**From:** [Christy Garcia](#)  
**To:** [Jeremy Johnston](#)  
**Subject:** RE: Request for Final Plat Review LPF-19-00003 Palomino Fields Div 2  
**Date:** Tuesday, March 26, 2019 11:09:44 AM

**From:** Jeremy Johnston  
**Sent:** Monday, March 18, 2019 10:53 AM  
**To:** Taylor Gustafson; Holly Erdman; Jesse Cox; Christy Garcia; Pat Nicholson  
**Subject:** Request for Final Plat Review LPF-19-00003 Palomino Fields Div 2

TO: Community Development Services  
FROM: Taylor Gustafson, Environmental/Transportation Planner  
DATE: March 26, 2019  
SUBJECT: LPF-19-00003 Palomino Fields Division 2

Surveyed by LMH Scale 1" = 300'
Drawn by Tml/FCS Sheet 1 of 5
Checked by FCS Project No. 18146

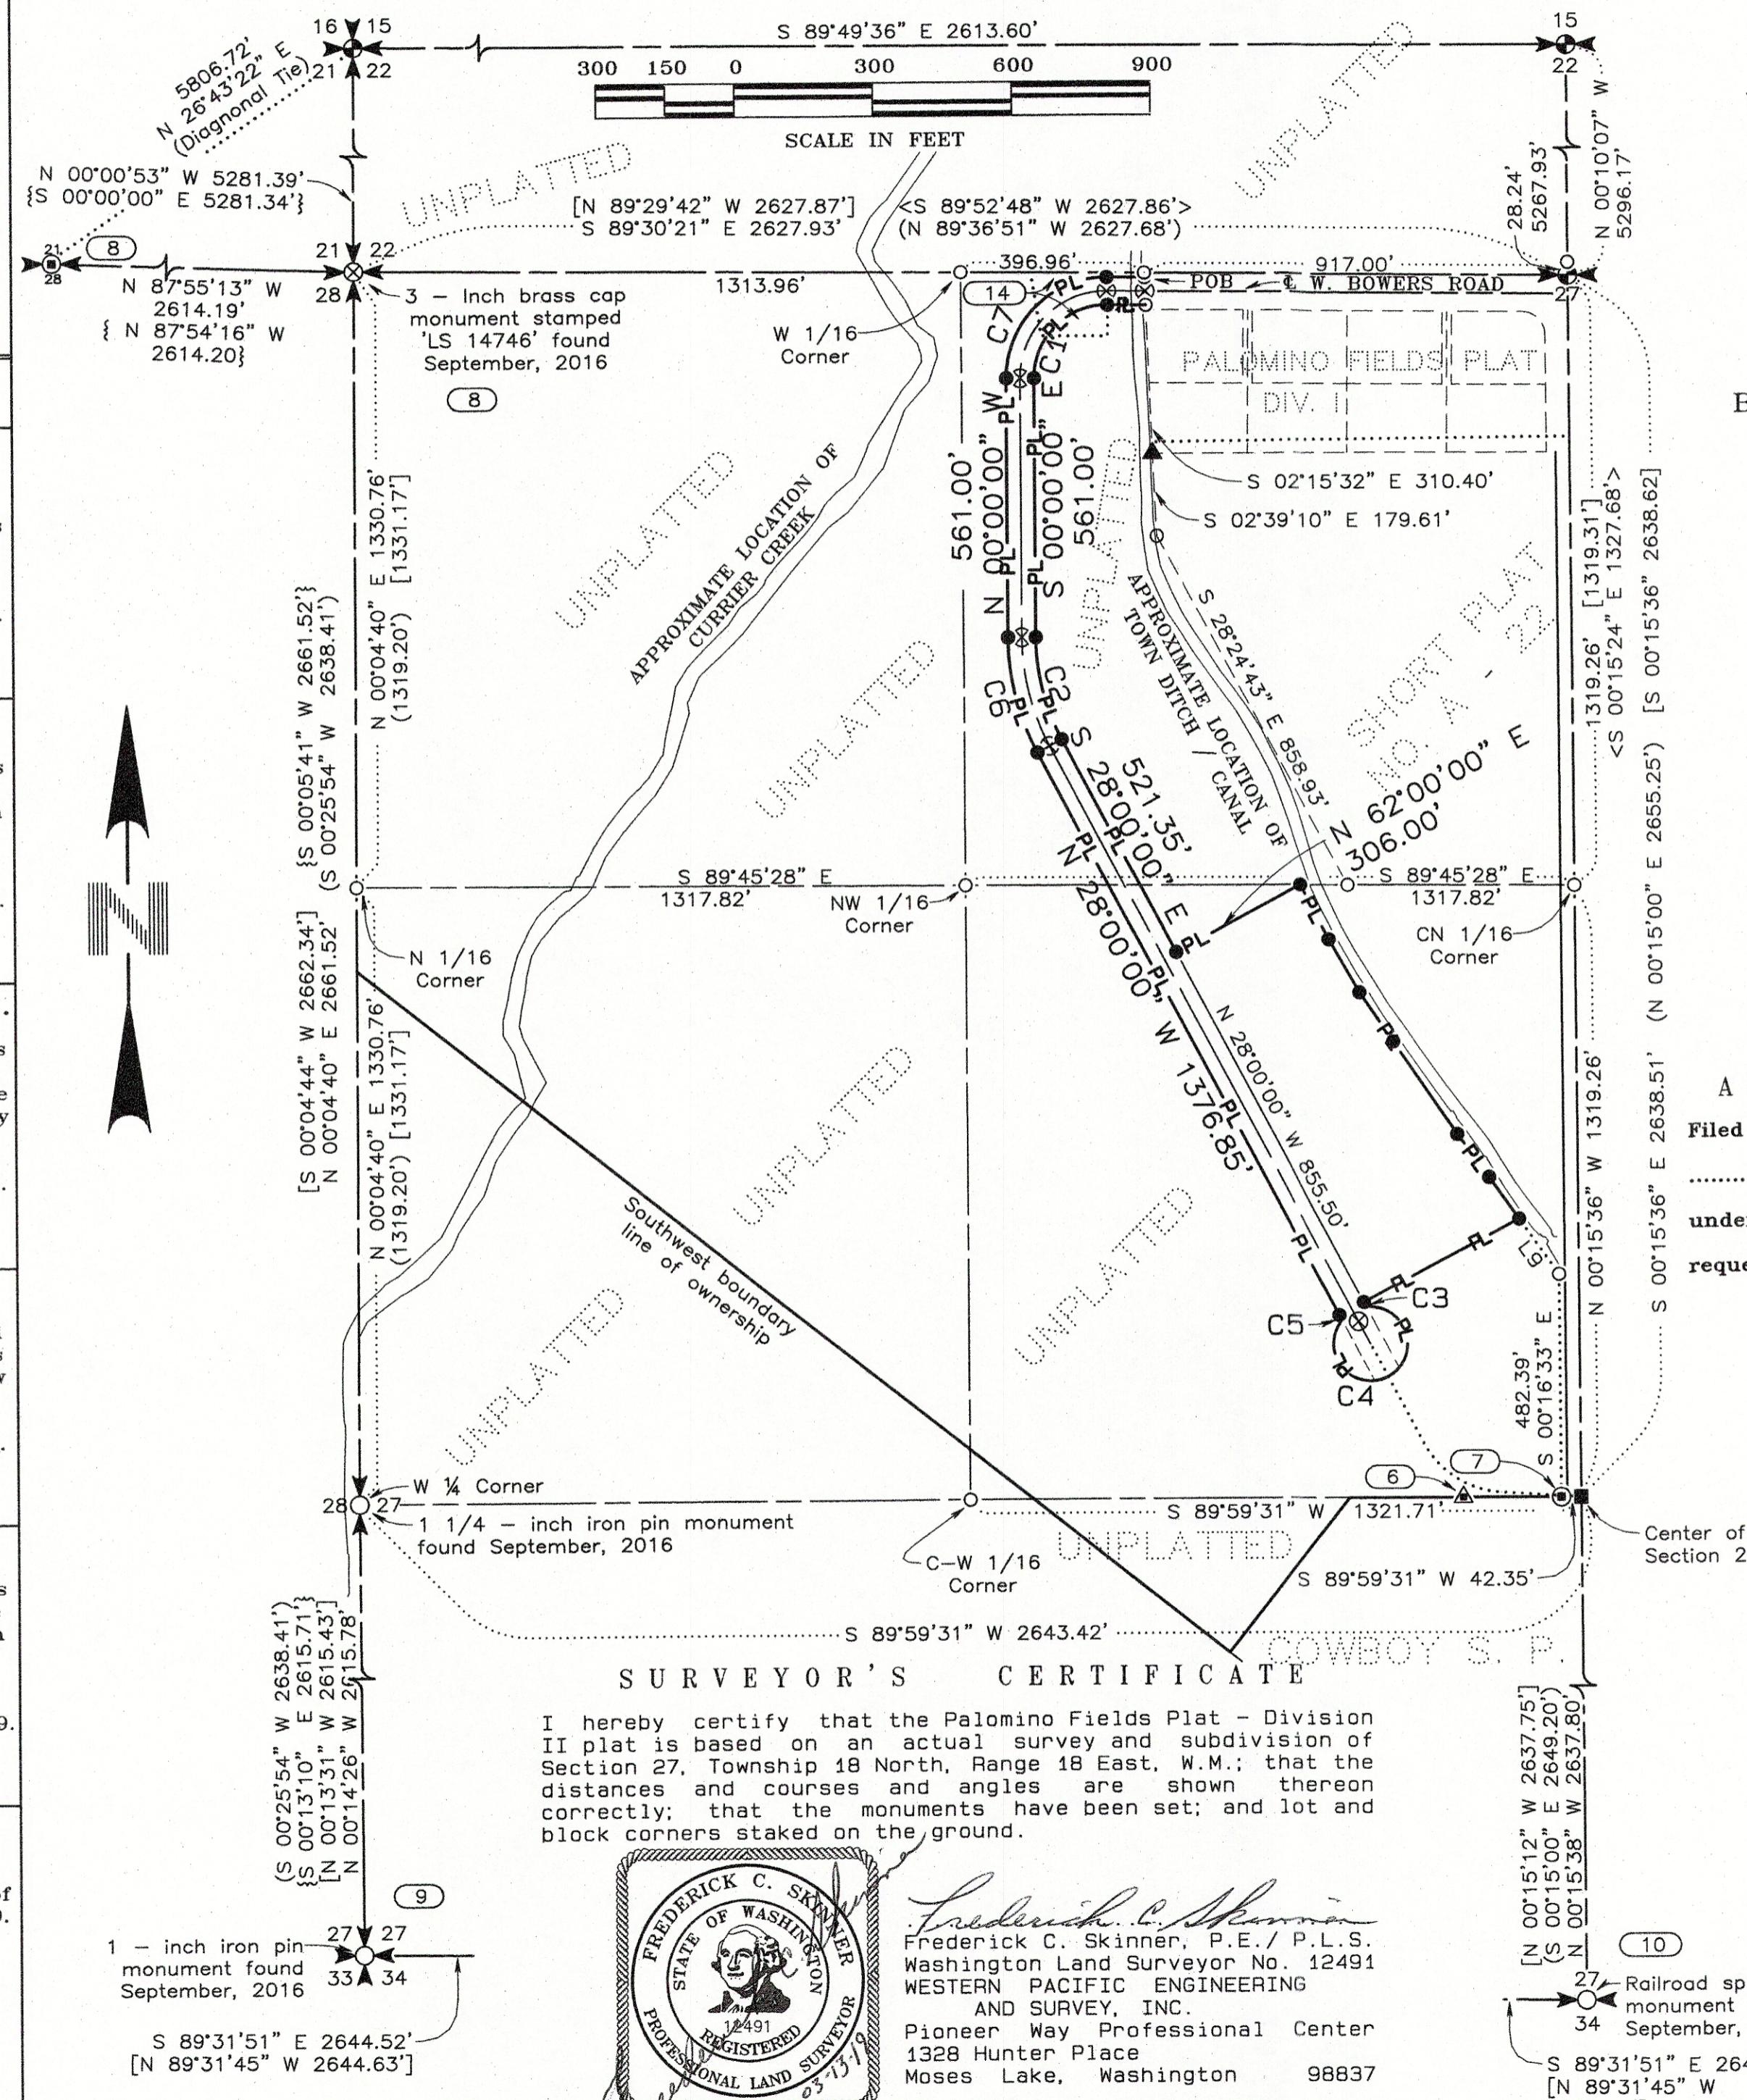
In reviewing the information on the preliminary survey documents, I noticed that between the Treasurer's and the Assessor's signature box a couple of errors. The Treasurer's box only lists a single incorrect parcel number of 471033, the correct number is 491033. Parcel number 471033 was retired during the creation of Palomino Fields Division 1 to create eight new parcel numbers. This is also incorrectly listed in the Assessor's signature box.

There are also two additional parcels involved (11801 & 11802) and they are listed correctly in the Assessor's signature box, but not listed in the Treasurers.

5. The exclusive use statement refers to the named parties in the Surveyors statement.
6. There are no named parties in the surveyor's statement (multiple sheets).
7. The proposed division actually involves a number of parcels, owned by two separate entities. The limits of all the involved parcels need to be surveyed with locations shown on the face of the plat. The concept of a "Parent Parcel" is the original lands involved, prior to proposed subdivision. The practice of outlining the project limits, and labelling them to be the parent parcel, is contrary to standard survey practice. Also note that the remaining area of the involved lots will need to be labeled with a lot, parcel or tract name as well as an area.

Surveyed by LMH Scale 1" = 100'
Drawn by Tml/FCS Sheet 2 of 5
Checked by FCS Project No. 18146

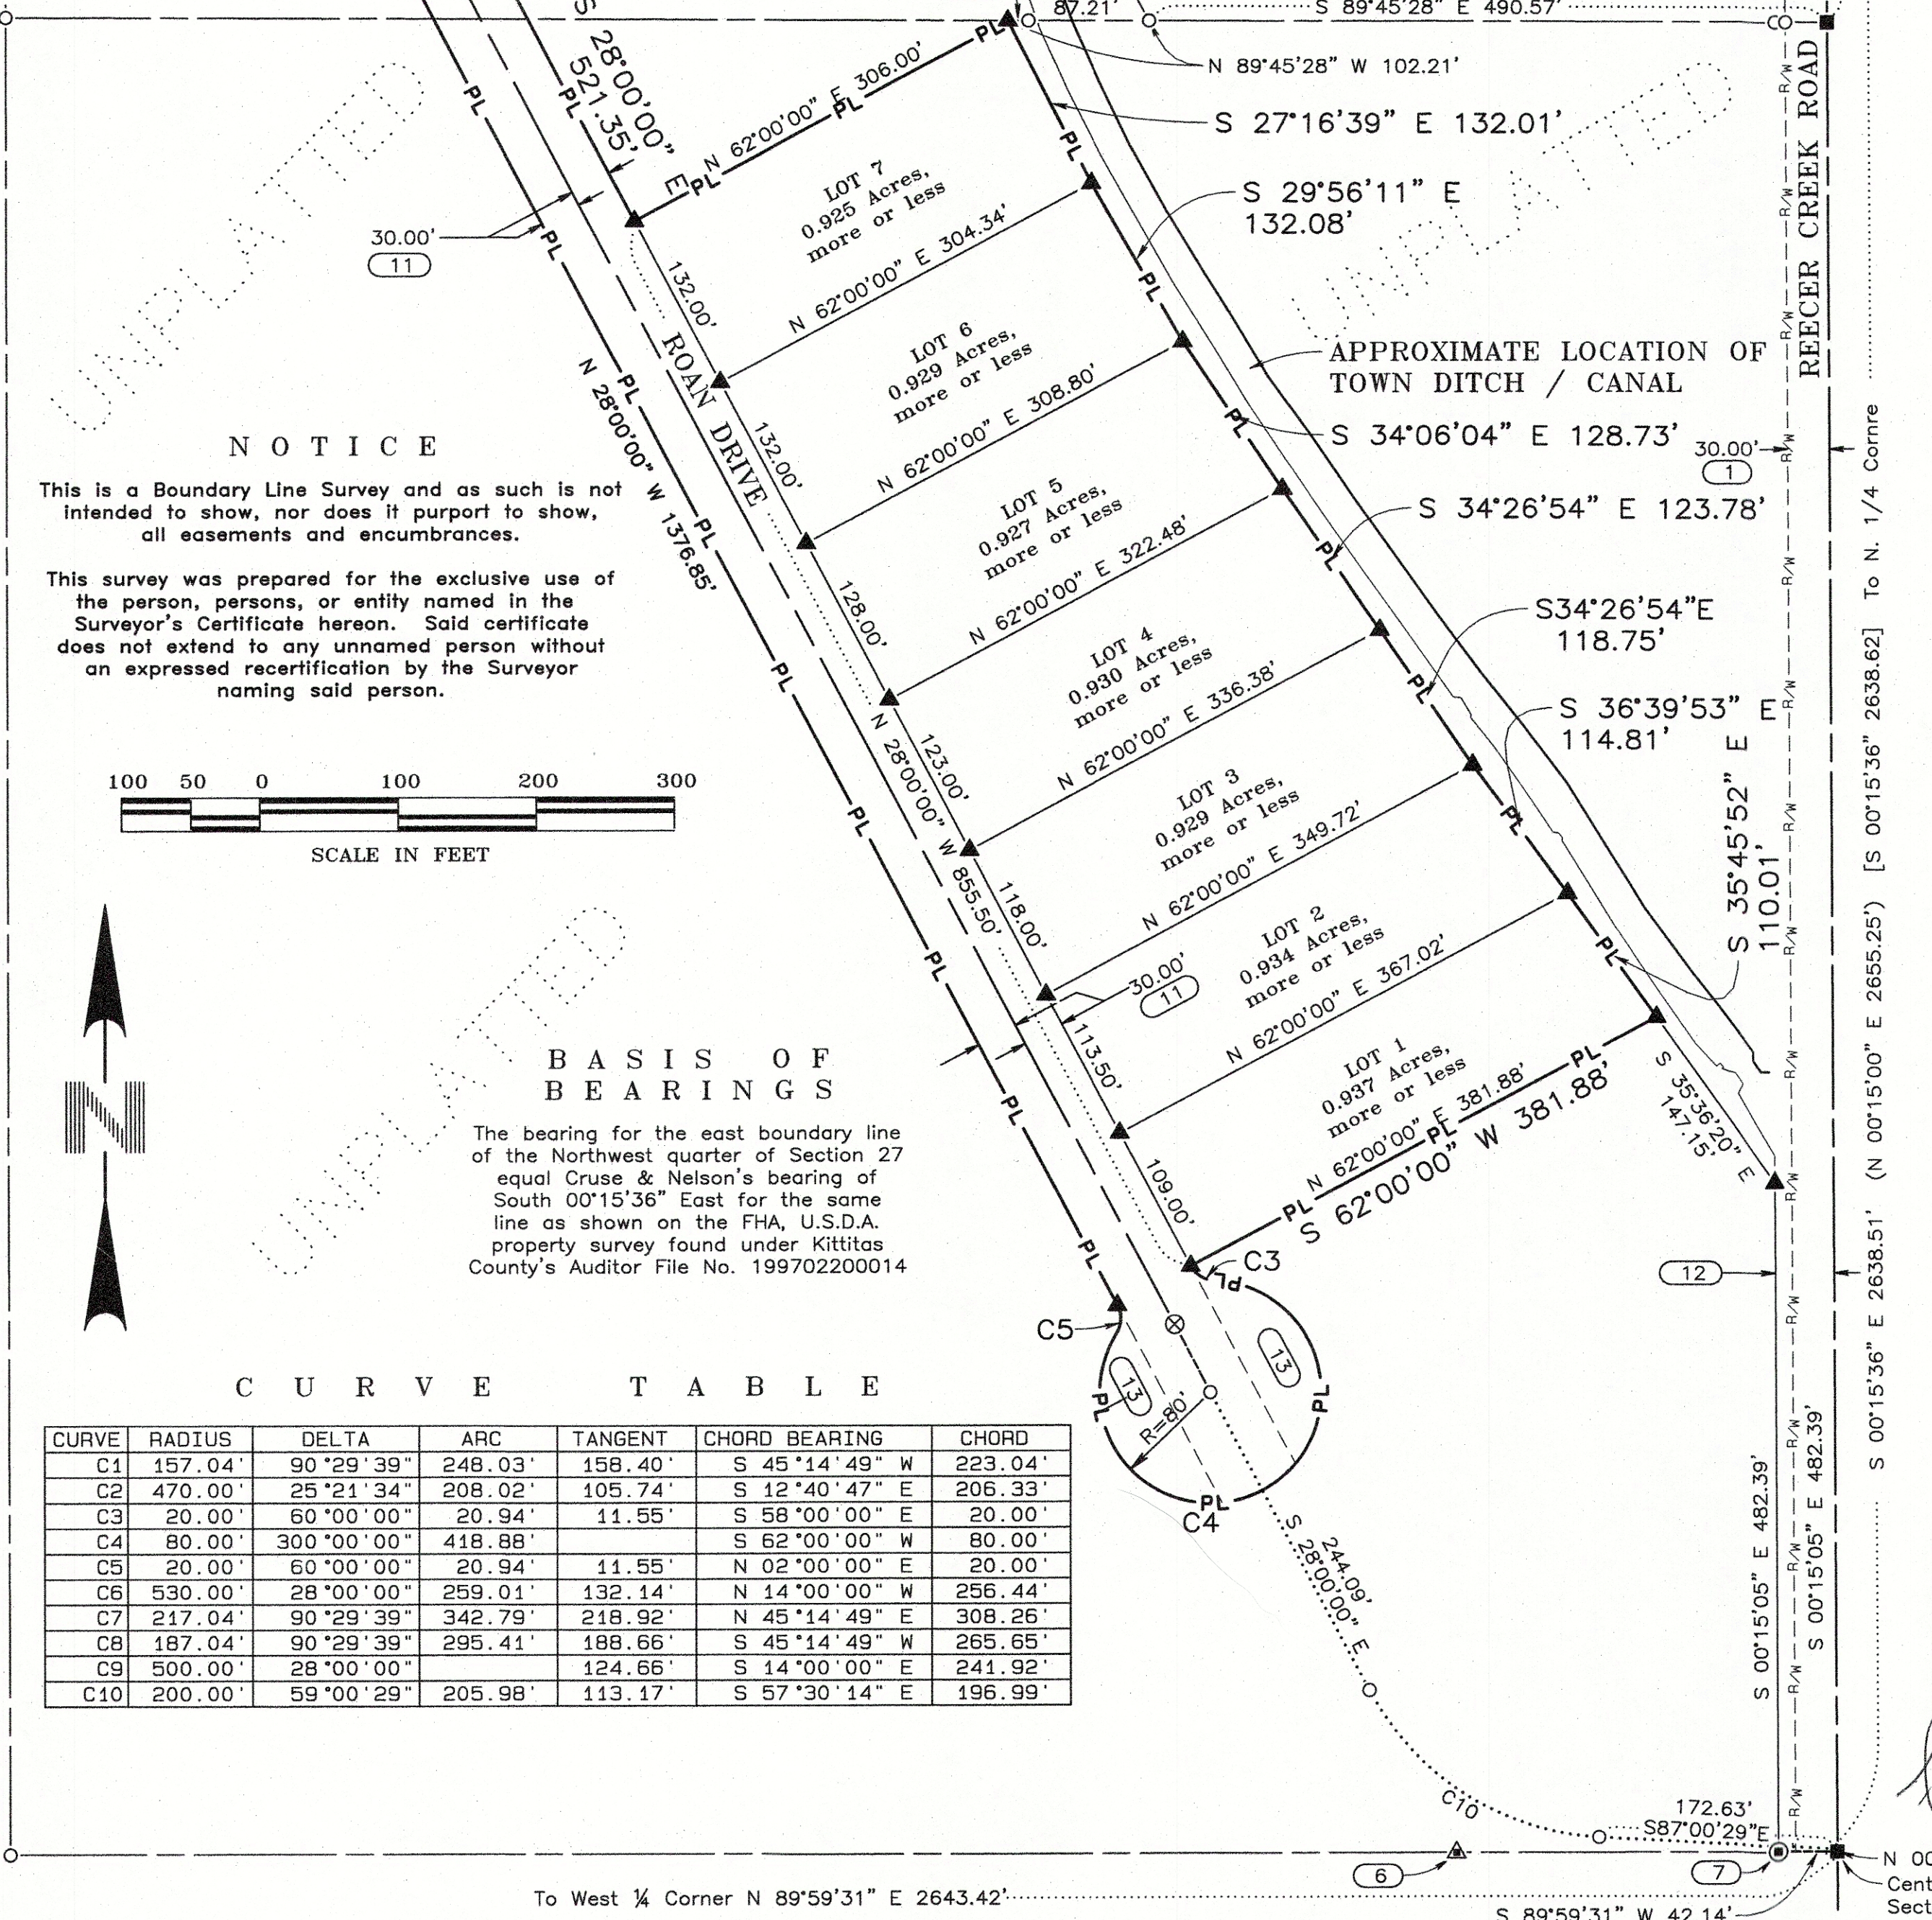
8. As the Easternmost boundary lines of lots 1-7 fall against the town ditch canal, it is assumed that the canal boundary is coincident with the lot boundaries. It is also assumed that the

areas shown as being “more or less” may reflect the ambulatory nature of bodies of water OR the necessity of lot owners to be able to make claim to additional lands in the event additional data is discovered locating the deed description of the canal. A note explaining such would greatly assist future parties.

9. In the legend, the text adjacent to the fourth symbol has a questionable date. If dates unknown, not labelling any date at all would be sufficient.
10. Curve 2 contained within the curve table appears to be incorrect, as it does not match the closure report.
